# OBSERVATION/SUBMISSION TO PLANNING APPLICATION

Case Reference: 324113

**Re: Observation to the proposed development of open-cycle gas turbine (OCGT) and generator with ancillary equipment.**

Location: Pollnagroagh and Rathmorrissy (Townlands), Athenry, Co. Galway

Purpose		PLANNING			
Title		SITE ACCESS SIGHTLINES			
Original Scale	Design/Drawn	Checked	Authorised		
SHOWN at A1	PS	ND	AJB		
Date	Date	Date	Date		
01.12.25	01.12.25	01.12.25	01.12.25		
Status	Drawing Number	Rev			
A2	PEK3-ATK-ZZ-01-DR-CE-901200	0

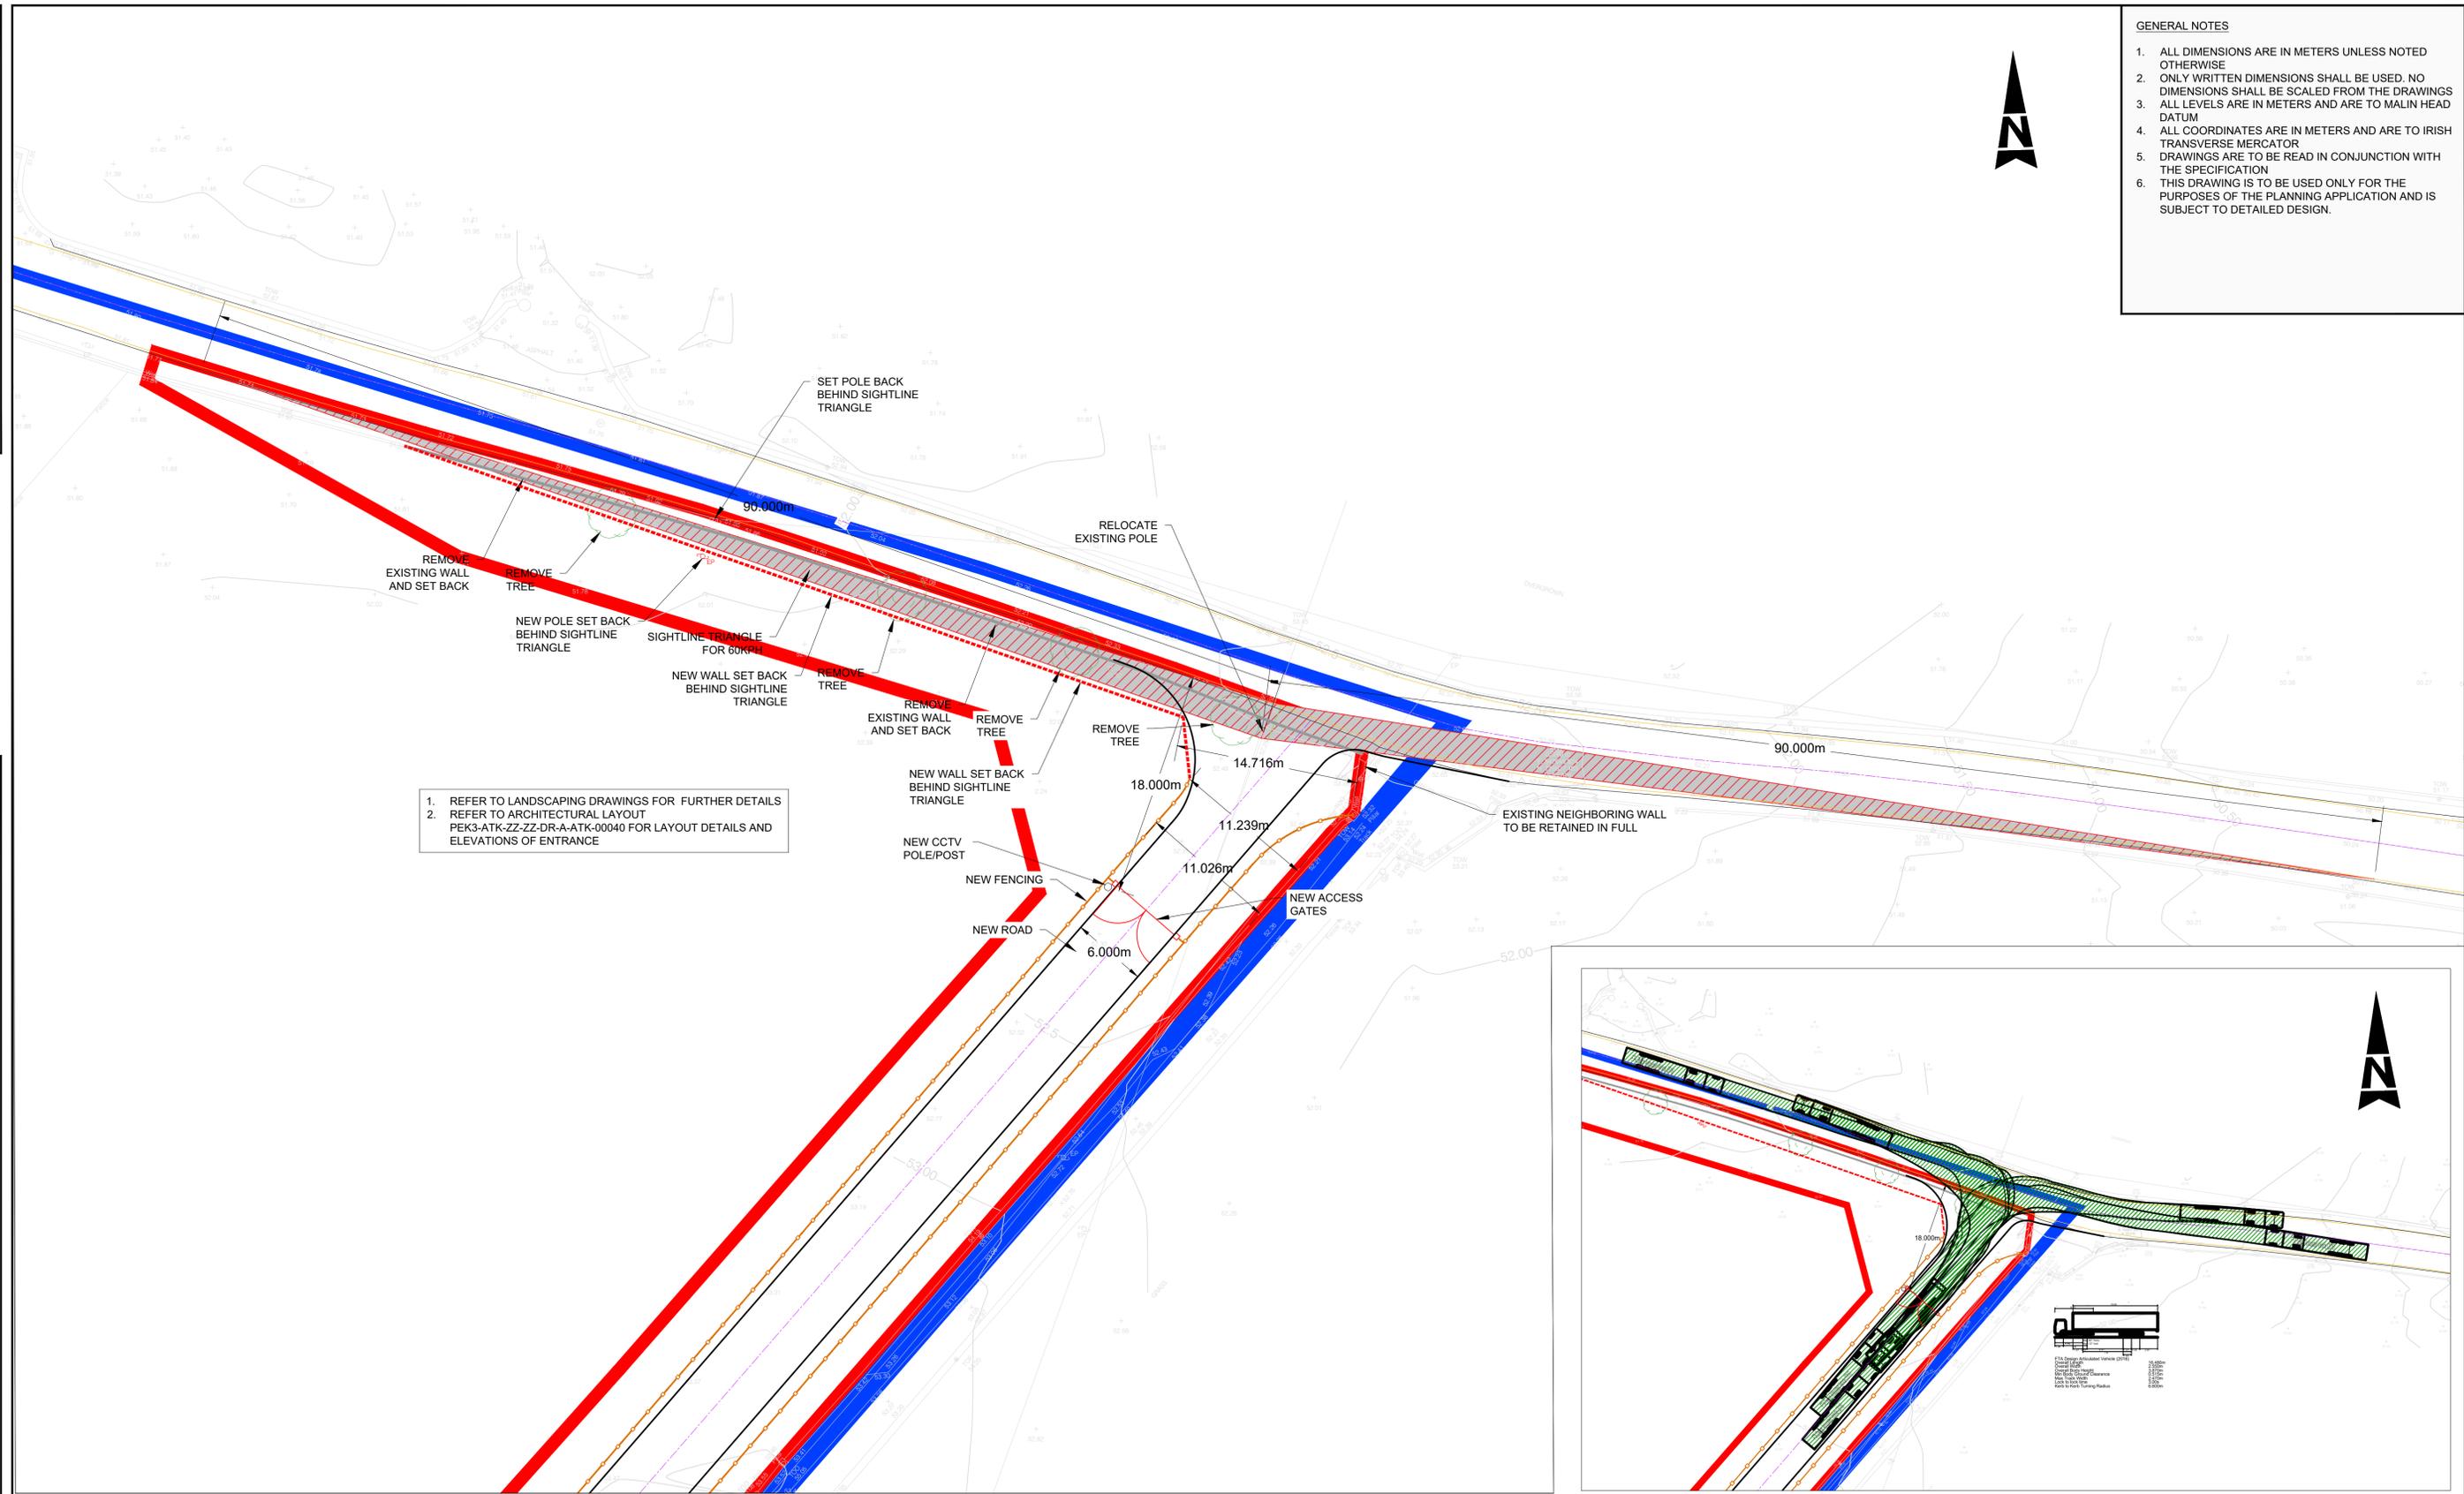
As someone who lives locally and uses this road, I am concerned about road safety in relation to the proposed entrance on the L3103. This stretch of road is already extremely narrow, with no hard shoulder, making it difficult for two heavy goods vehicles to pass safely and leaving no margin for error. Visibility is also poor due to blind dips and sharp bends, meaning drivers often cannot see oncoming traffic in time. The proposed development would increase traffic levels, including heavy goods vehicles, construction traffic, and fuel deliveries such as diesel tankers, all of which require space and clear sightlines that this road does not provide.

As someone who lives locally and extensively uses this road, I am concerned about the proposed location of the site entrance on the L3103. This section of road is already extremely dangerous, as it is narrow, has no hard shoulder, and does not provide sufficient space for two heavy goods vehicles to pass safely. Visibility is also poor due to blind dips and sharp bends, meaning drivers often cannot see oncoming traffic in time, and introducing a site entrance at this location would significantly increase the risk to all road users.

There are serious concerns about the proposed site entrance on the L3103, which is an exceptionally dangerous stretch of road where introducing an access point would create an unacceptable level of risk. The road is extremely narrow and cannot safely accommodate two heavy goods vehicles passing at the same time, there is no hard shoulder to allow for safe manoeuvring or recovery, and visibility is severely limited due to blind dips and sharp corners. These are significant existing hazards that already pose a real danger to road users, and the addition of a site entrance would further increase that risk.

The placement of a site entrance at this hazardous location on the L3103 raises serious safety concerns. The road is already constrained by its narrow width, the absence of a hard shoulder, and extremely poor visibility due to blind dips and sharp corners, yet the Environmental Impact Assessment does not appear to fully address the safety implications of introducing an access point at this location. There are also concerns that the cumulative impact of additional traffic has not been properly assessed, including construction traffic, ongoing operational traffic, and fuel deliveries, and the interaction between heavy goods vehicles and existing road users—such as local traffic, school-related movements, and agricultural machinery—has not been
